# SADDLEHORN RANCH - FILING NO. 2

EPC STORMWATER REVIEW COMMENTS ARE SHOWN IN ORANGE BOXES WITH BLACK TEXT

## PRE-DEVELOPMENT GRADING AND EROSION CONTROL PLANS

PCD FILE NO. EGP221

SADDLEHORN RANCH - FILING NO. 2  
EARLY GRADING IMPROVEMENTS  
SHEET 4.1 OF 14  
JOB NO. 2514204

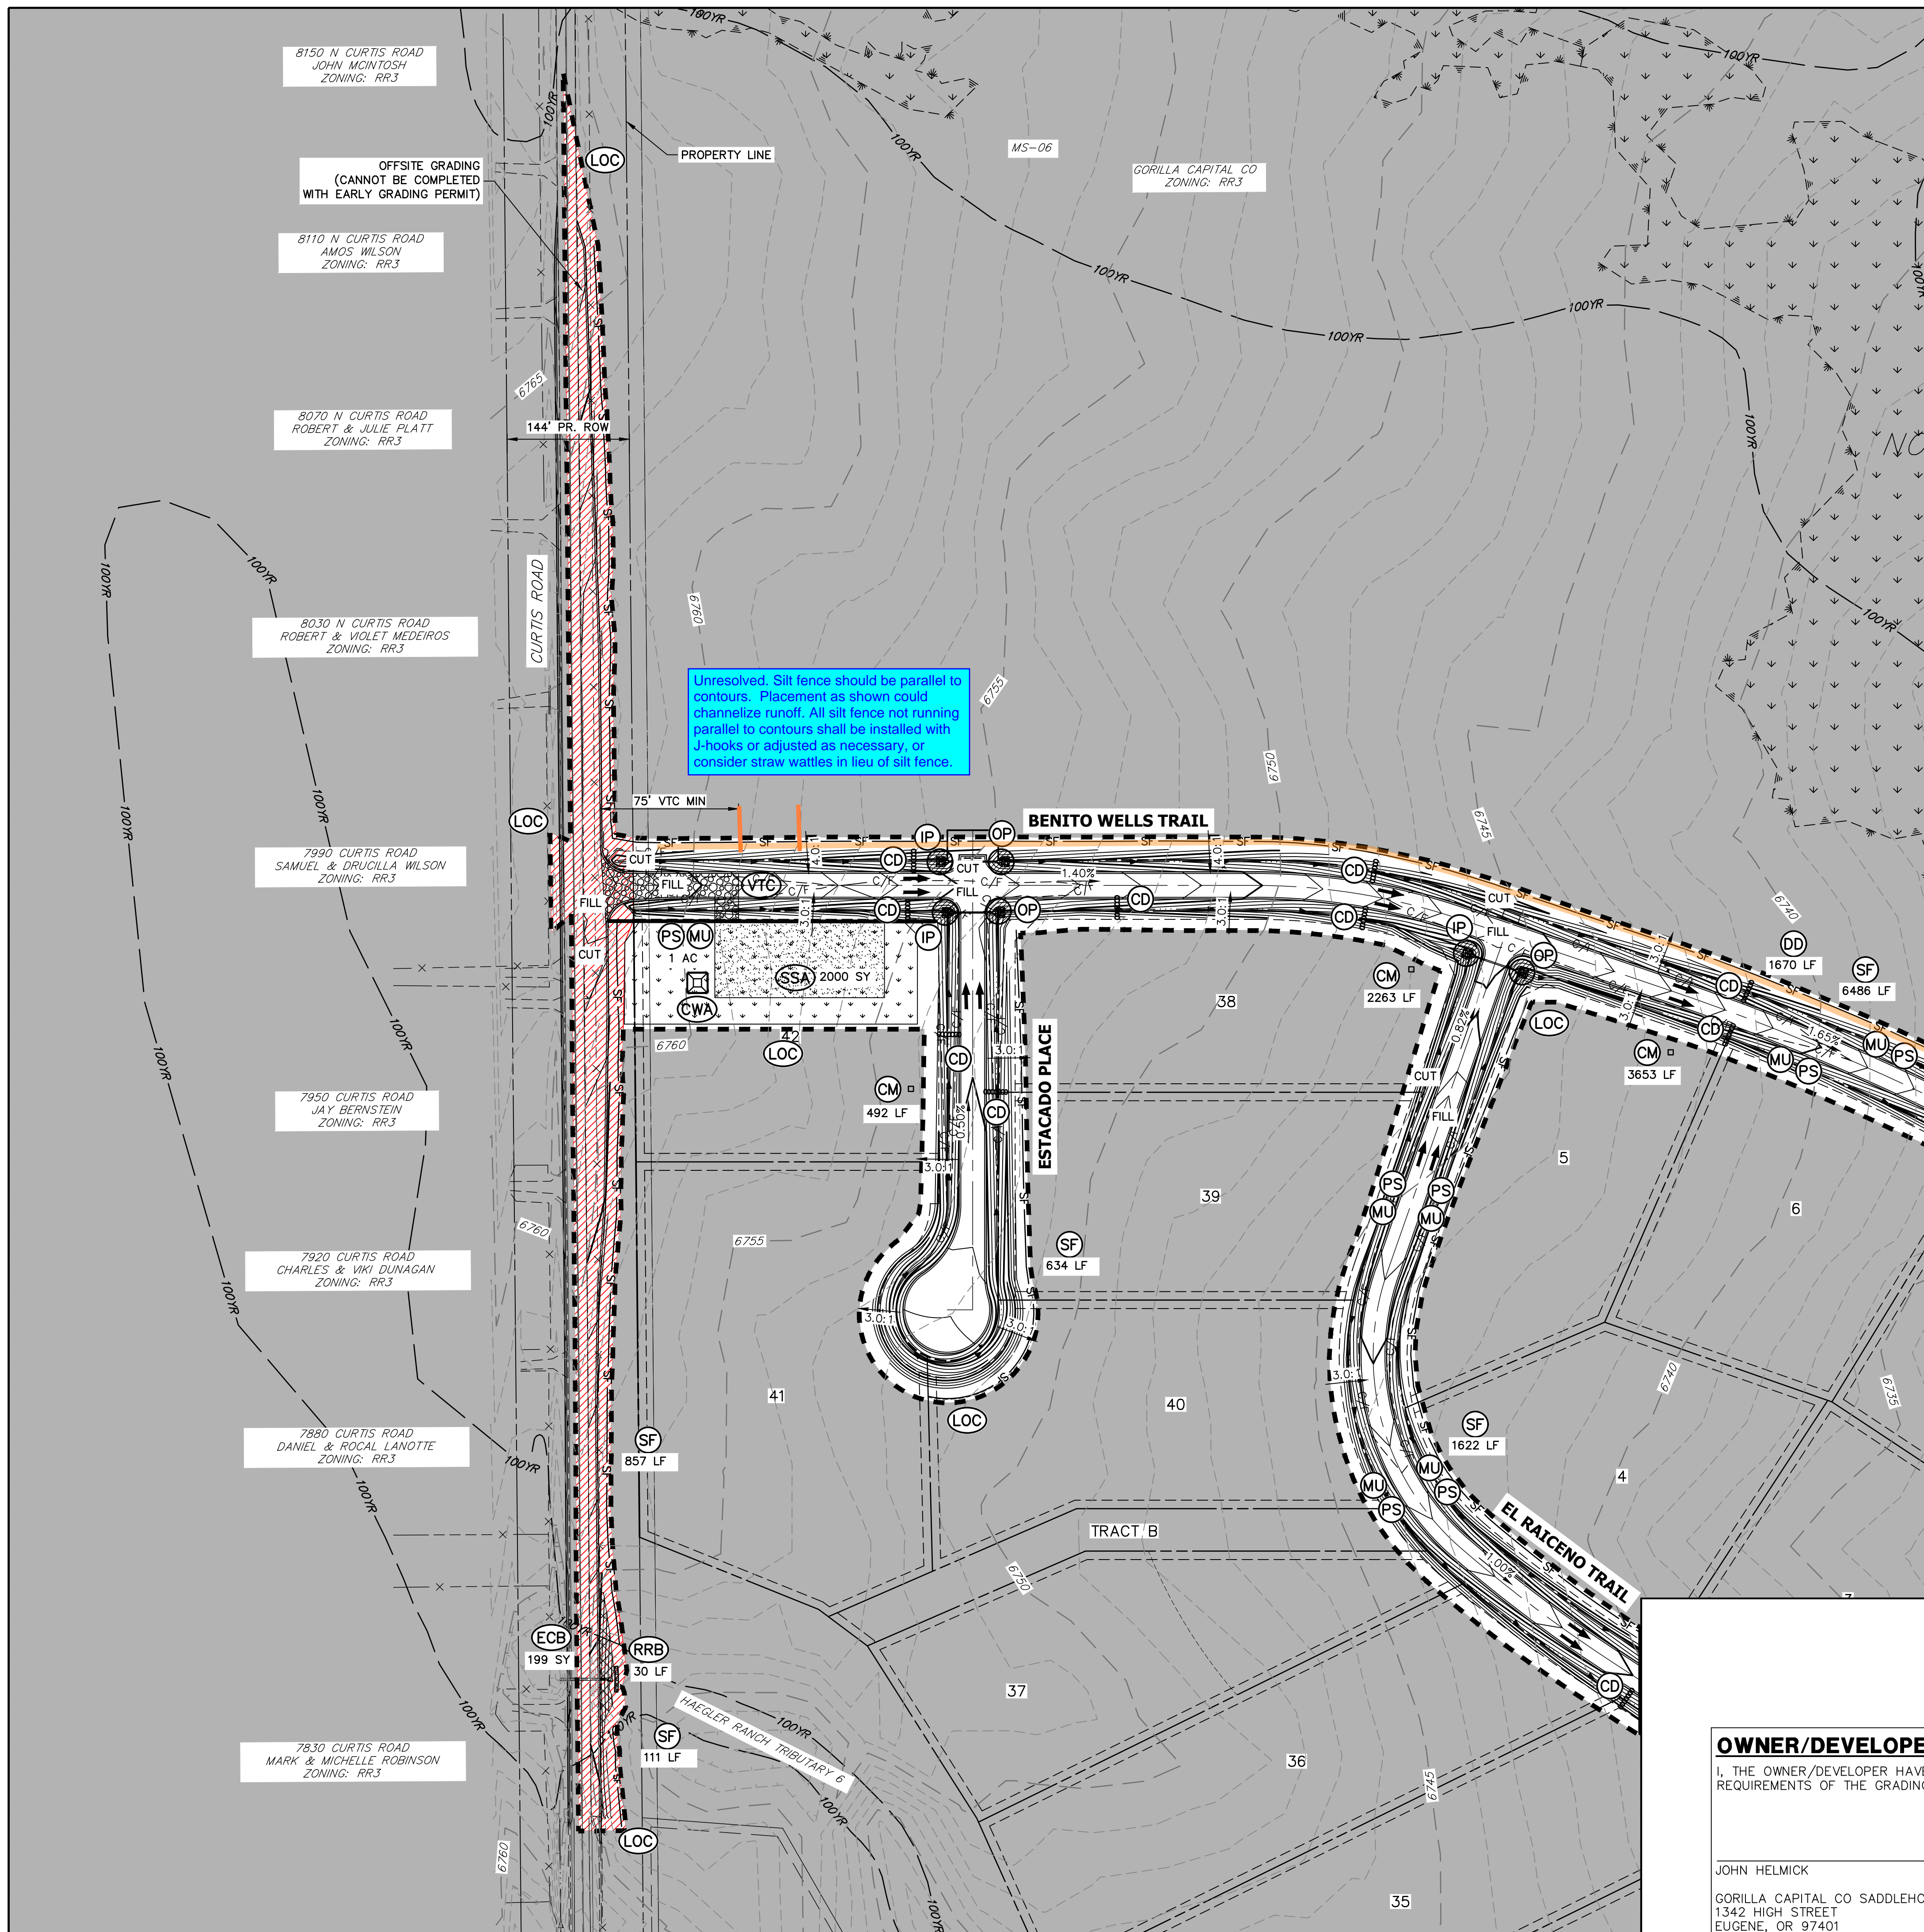
Provide culvert profiles for the dual 24" RCP culverts. Are these culverts permanent?

Also provide construction detail showing erosion protection and horizontal distance between pipes.

JR: Erosion protection for the culverts is shown on page 7 denoted as IP and OP. Details for IP and OP can be found on pages 12 and 11 respectively. The label for the dual culverts has been updated to call-out the distance between the two culverts.

JR: Culvert labels have been updated to show inverts, slope, and cover. Per conversation with Elizabeth

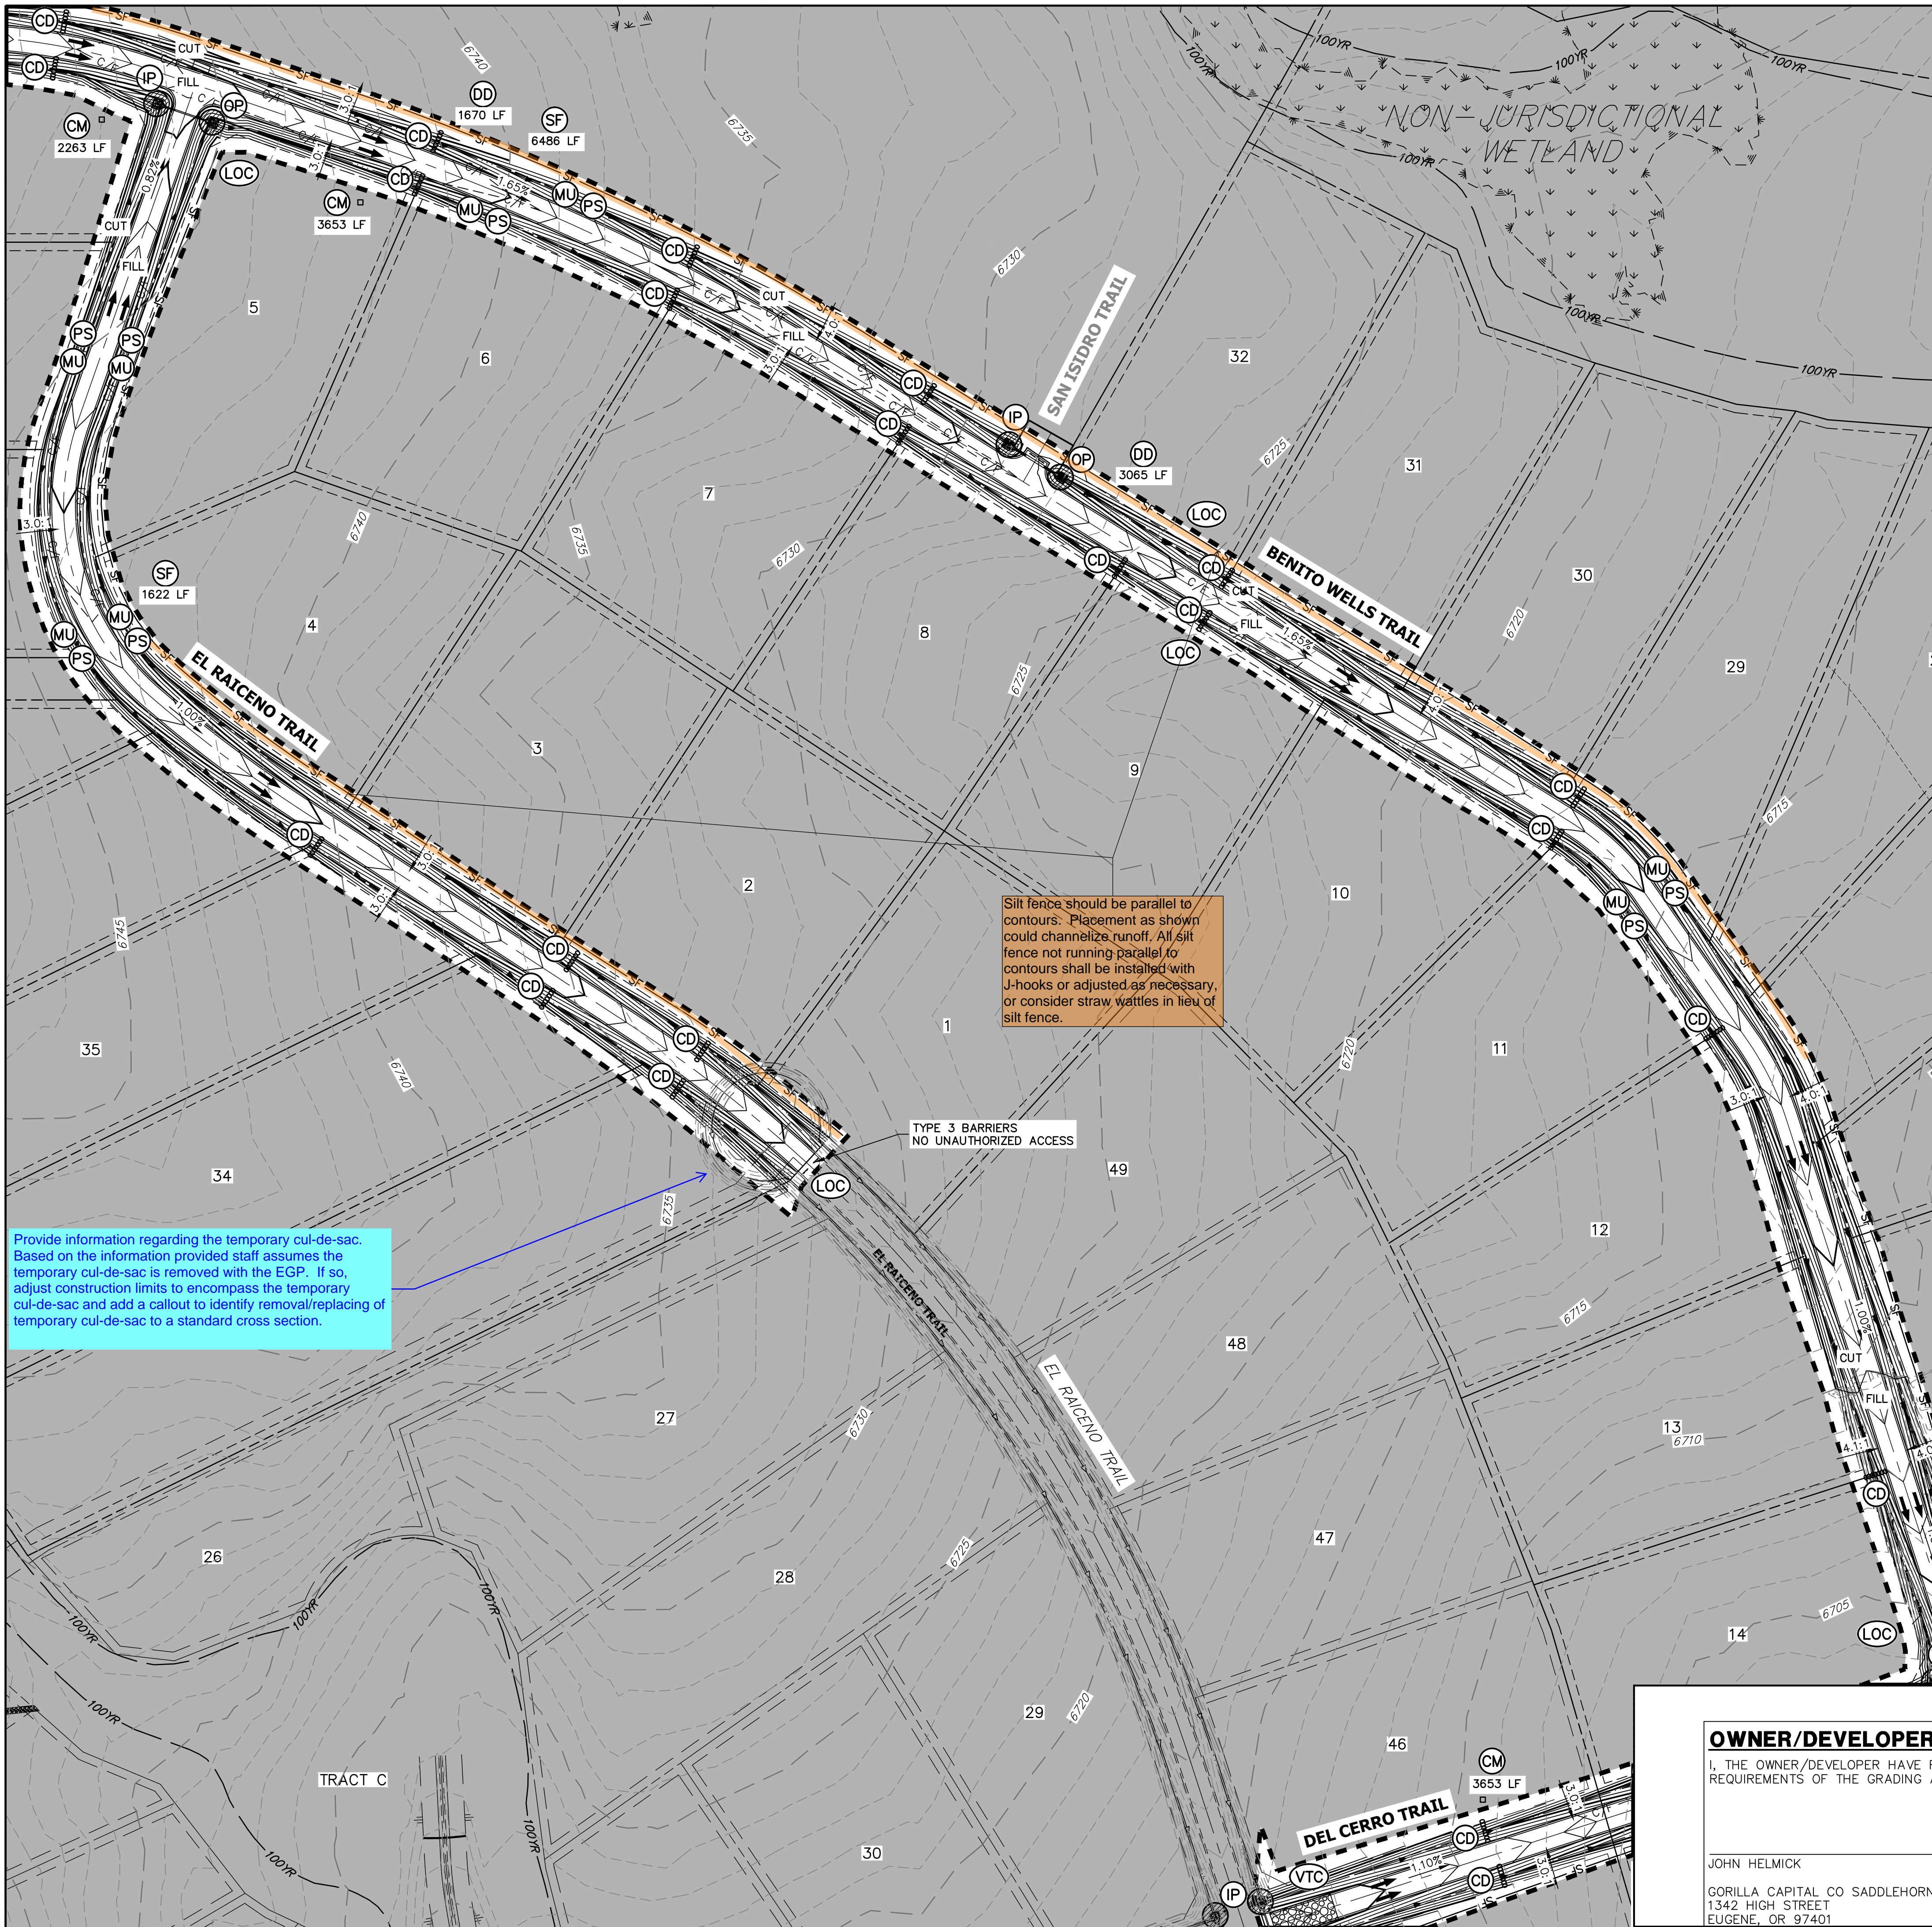
Unresolved. Silt fence should be parallel to contours. Placement as shown could channelize runoff. All silt fence not running parallel to contours shall be installed with J-hooks or adjusted as necessary, or consider straw wattles in lieu of silt fence.

Silt fence should be parallel to contours. Placement as shown could channelize runoff. All silt fence not running parallel to contours shall be installed with J-hooks or adjusted as necessary, or consider straw wattles in lieu of silt fence.

JR: See note 8. Per conversation with Elizabeth

JR: See note 8. Per conversation with Elizabeth

Provide information regarding the temporary cul-de-sac. Based on the information provided staff assumes the temporary cul-de-sac is removed with the EGP. If so, adjust construction limits to encompass the temporary cul-de-sac and add a callout to identify removal/replacing of temporary cul-de-sac to a standard cross section.

JR: Label added stating that the temporary cul-de-sac is not to be disturbed during early grading operations. The cul-de-sac will be removed when the rest of the filling 2 roads are paved.
